Application number: 2024/91432	
What is the application for?:	Erection of rear dormer and hip to gable roof
Address of the site or building:	Holmeview, 1, Longden Avenue, Beaumont Park, Huddersfield, HD4 5JD
Postcode:	HD4 5JD

Type of comment: An objection	
Do you wish your comments to be published on the website anonymously?	Yes
1st July 2024 For the attention of Ms Laura Yeadon, Case Officer for Kirklees Planning and Development Dear Madam Re: Application No. 2024/62/91432/W Holmview, 1 Longden Avenue, Beaumont Park, Huddersfield, HD4 5JD for proposed hipped roof changed to gable roof and rear dormer We write on behalf of , the owner of , Beaumont Park, Huddersfield with reference to the proposed works at 1 Holmview Longden Avenue, Beaumont Park, Huddersfield, HD4 5JD as outlined in the submitted application form and accompanying drawings. We note that there was an application in 2021 reference 2021/90720 which initial proposals were rejected due to overdevelopment and the 'host property becoming subservient'. We note that the subsequent revised application was agreed with the planning department and supported by a local councillor behind closed doors as the 'amended plans were c

CLIENT	Mehreen		
ADDRESS	1 Longden Avenue HD4 5JD, Beaumont Park		
PROJECT	Hip to Gable and Rear Dormer		
DRAWING	Existing/Proposed Layout and Elevations		
DRAWN	UH	DATE	Sept 22
		SCALE	1.50@A1
DWG No.	2406/01		
STATUS	PLANNING

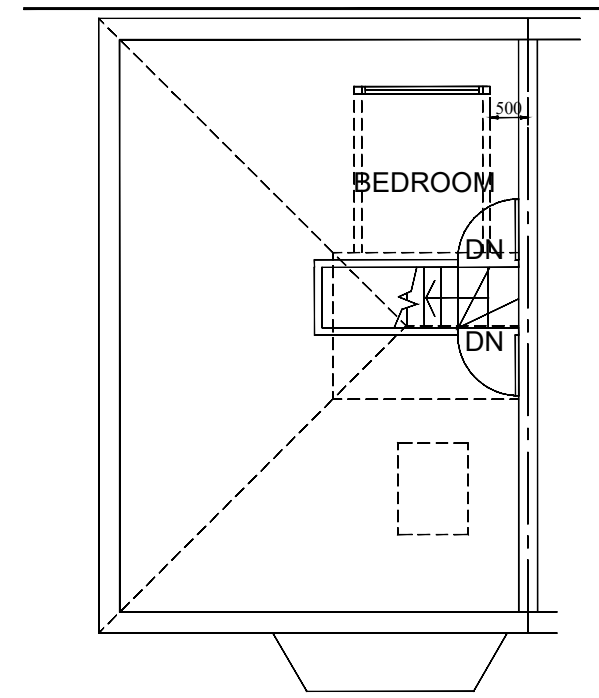
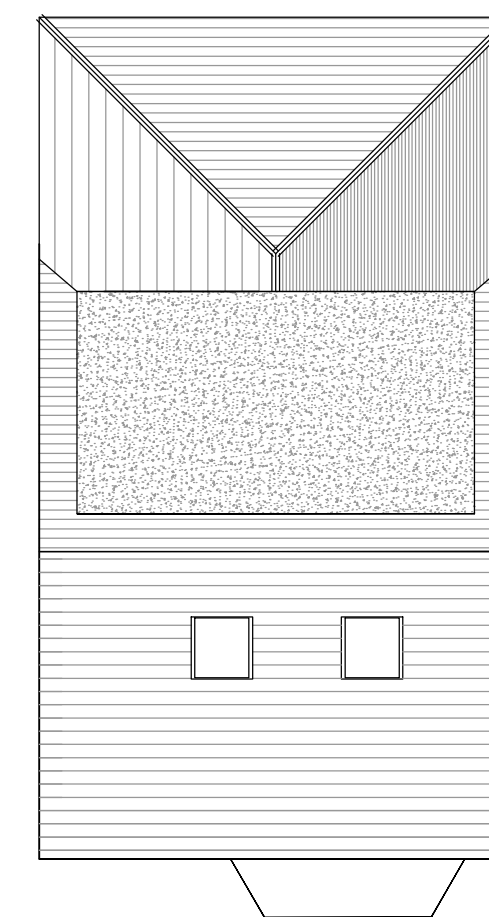
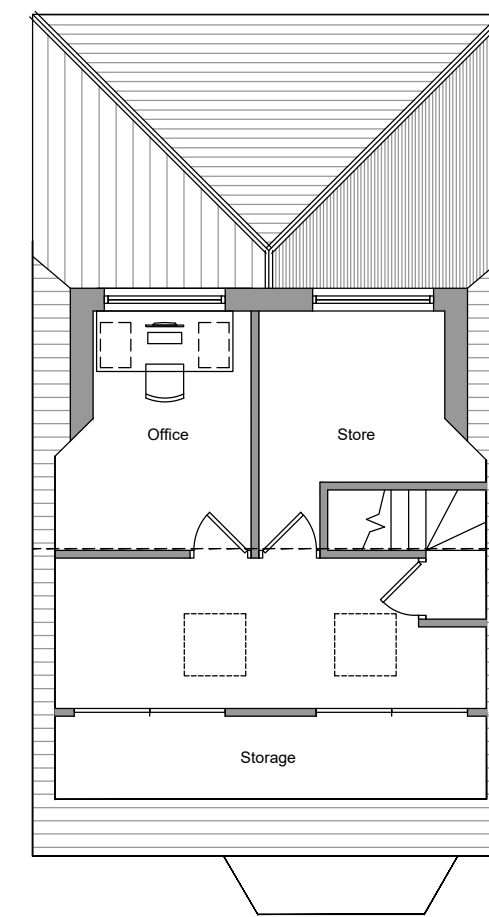
We note that the latest proposals are now applying for the same increase in floor area at second floor and the same large sized dormer across the extent of the rear elevation at roof level, which is as the previous rejected application 2021/90720, however, we assume that the limitations of extending a property and any extension or series of extensions must remain subservient to the host property. We do not now believe that this is the case.

Viewing this latest application it is apparent that the proposals are now more dominant than the host property and that the original build of a small 3 bed semi with standard sized 2 double beds and a box room has been superseded by a grander proportioned 3 double bedroom home with larger living accommodation. We note that the second floor area is designated as study and storage, however, we are sure that in time this will be changed to a large third double bedroom, and also cannot comprehend why this extension is required when the proposal indicates a storage room to replace loft storage and a redundant small loft bedroom to become a study. Is the gable and extended dormer necessary when these spaces already exist in the current planning consent.

overlooking, higher sill level larger windows will look straight into the side windows of
suspected loss of light for adjacent properties
over overshadowing and overbearing for adjacent properties
overdevelopment, the host property is subservient to the combined extensions
